DECISION DELEGATED TO HEAD OF PLANNING

Application No: H22-0510-23 **Applicant:** Spalding Developments Ltd.

Proposal: Erection of 3 Dwellings - approved under H22-0725-21. Modification of Condition 1 to allow amendments to previously approved plans.

Location: Rear Of 192 To 200 High Road Weston Spalding

Proposed Site Plan

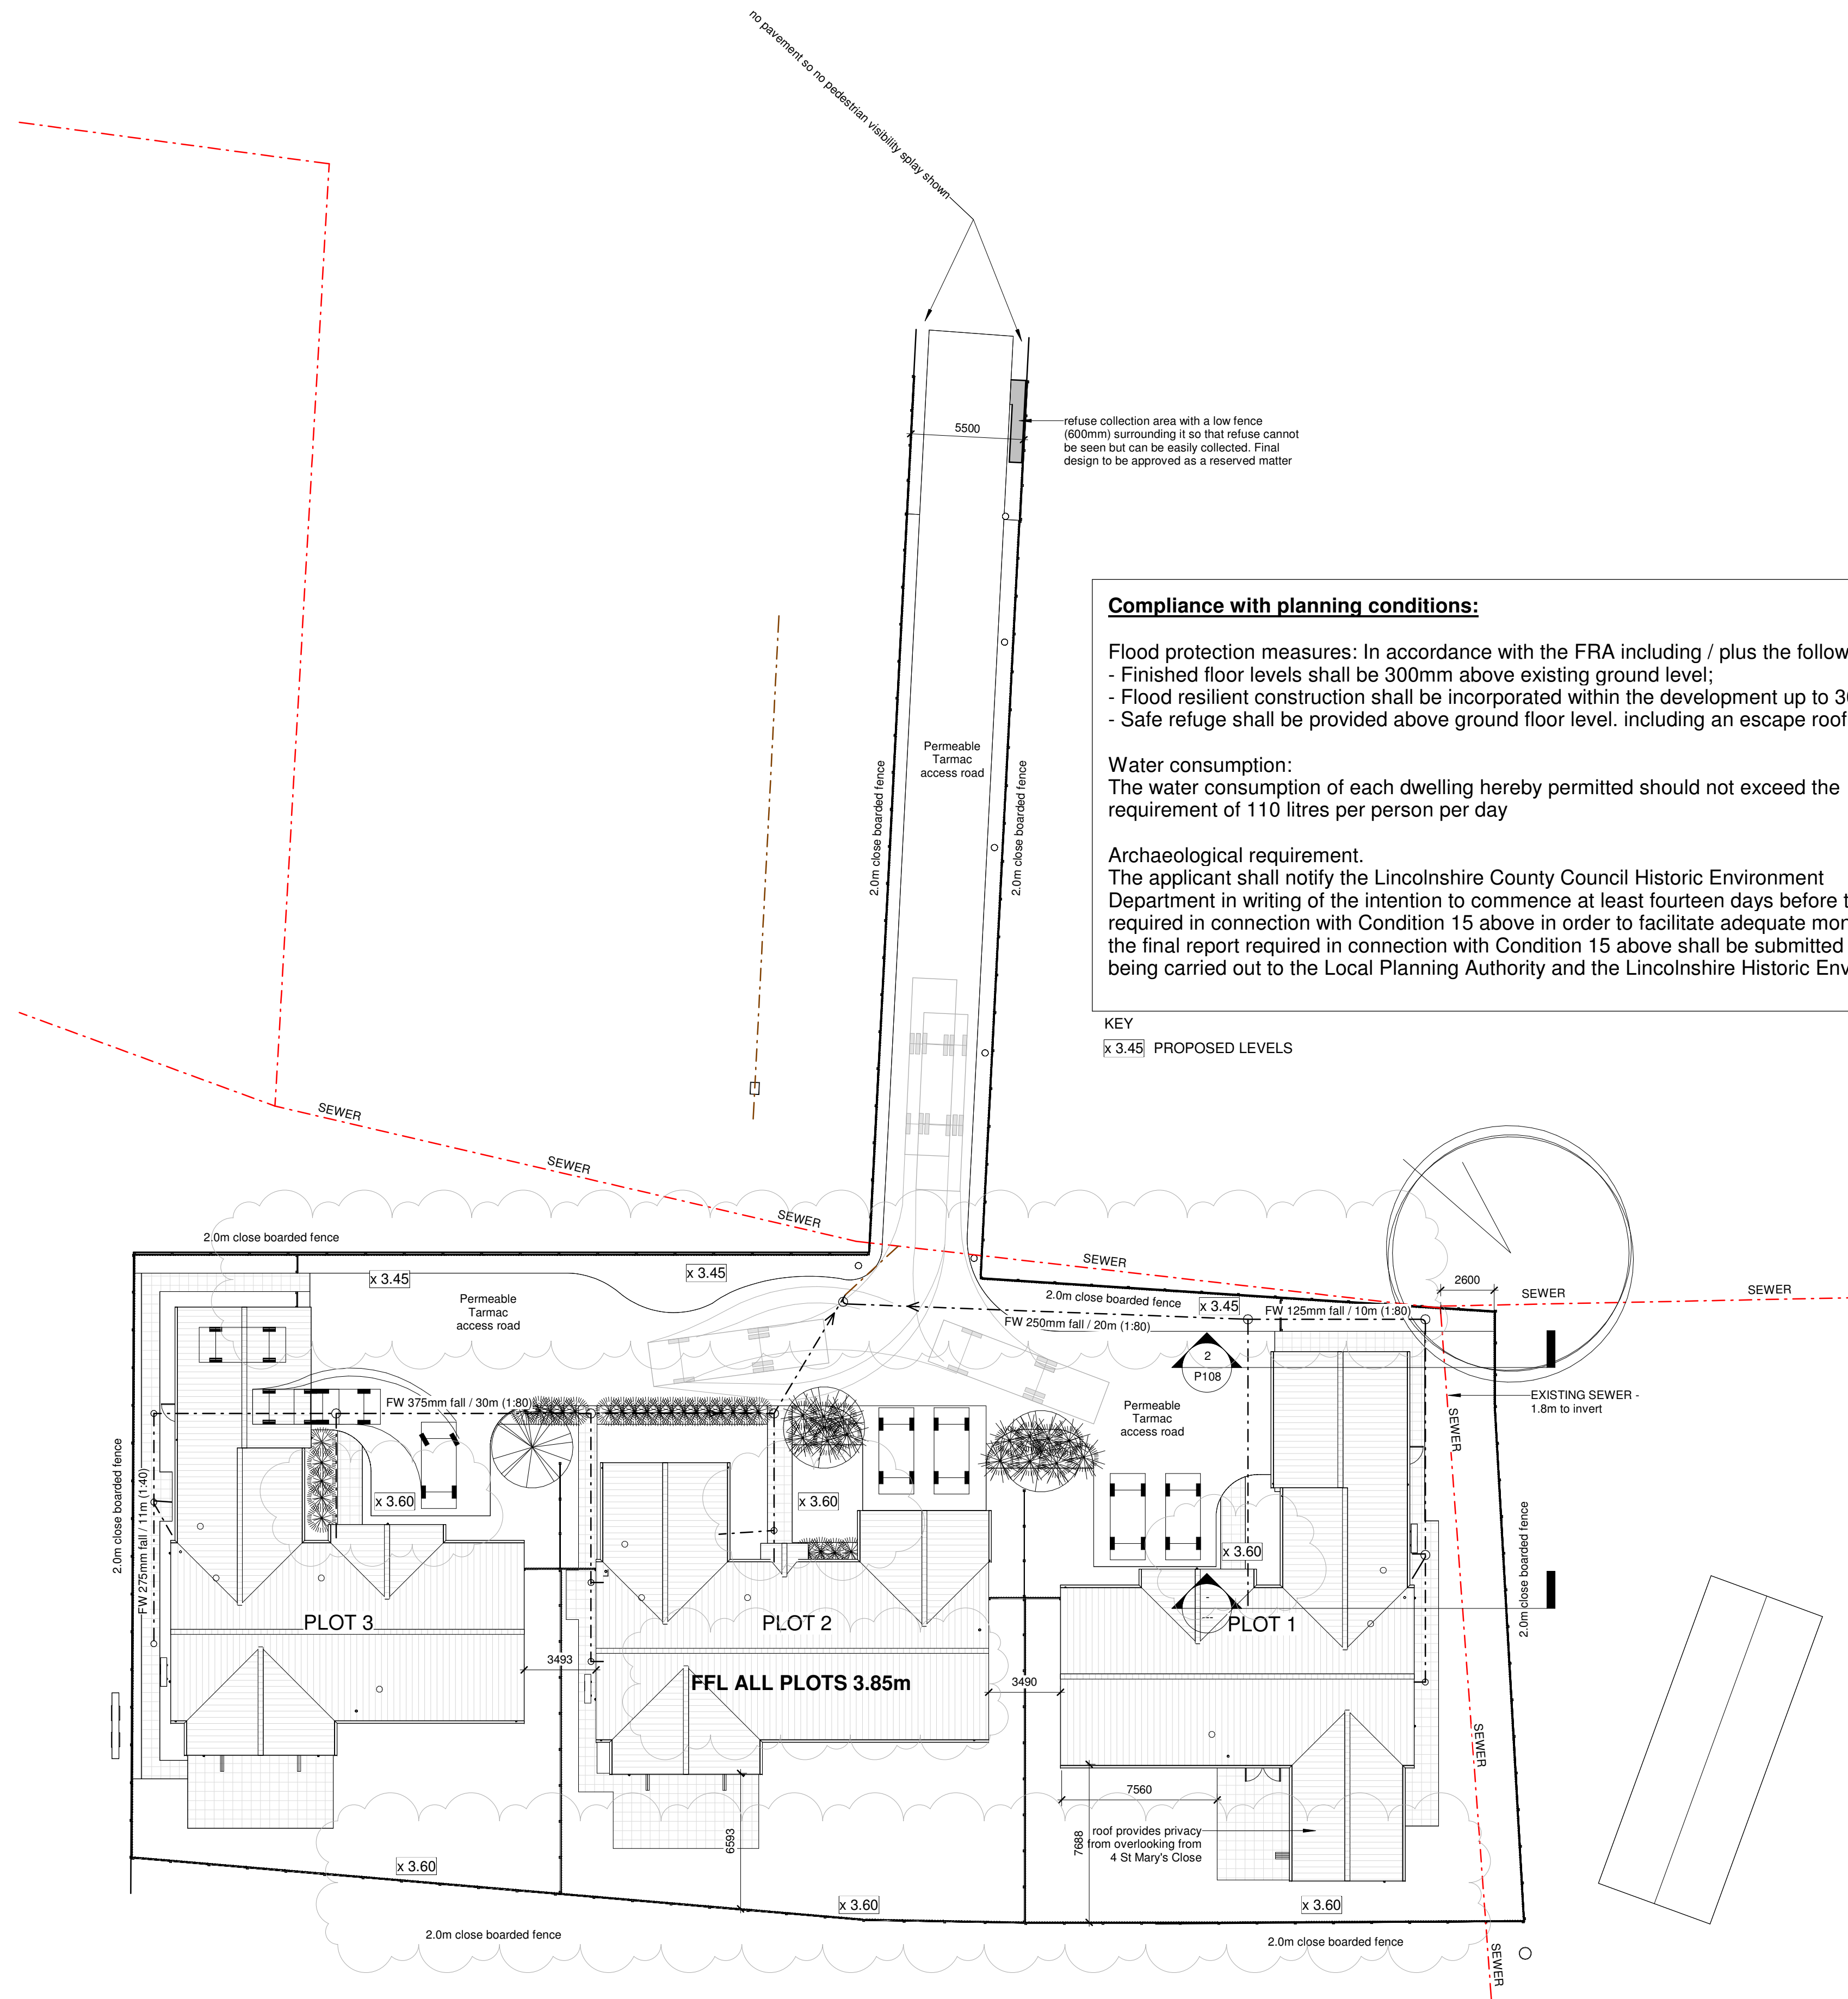
It is proposed to raise finished floor levels from 3.6m aOD to 3.85m aOD. As a result, 2m high close boarded fencing with 300mm trellising on top is proposed along the north-western boundary bordering semi-detached houses fronting High Road. Plot 1 has utility and garage doors, plus utility, en-suite and kitchen/living room windows on its north-eastern elevation facing No. 4 St. Mary's Close. 2 metre high fencing is proposed along the eastern boundary, other than adjacent the utility door and kitchen/living room window where it has been increased to 2m with 300mm trellis. Plot 3 has similar openings plus a secondary dining room window on its south-western elevation. 2 metre high close boarded fencing along the southern section of the boundary has been increased in height by the addition of 300mm trellising. The south-eastern (rear) boundary is mainly delineated by existing Leylandii located on neighbouring property. Fencing along the exposed section also includes 300mm trellising. It is considered that the amenity of neighbouring residents would not be materially harmed in terms of overlooking, lack of privacy, overshadowing, overbearing effect, noise and disturbance, etc. This is subject to a boundary screening condition to ensure that the proposed

LCC Highways has indicated that the amendments proposed will not have an adverse impact upon the public highway or surface water flood risk. The current proposal includes a bin collection area within the site. However, this should be located adjacent the highway as per the original plans because SHDC refuse vehicles do not enter private drives.
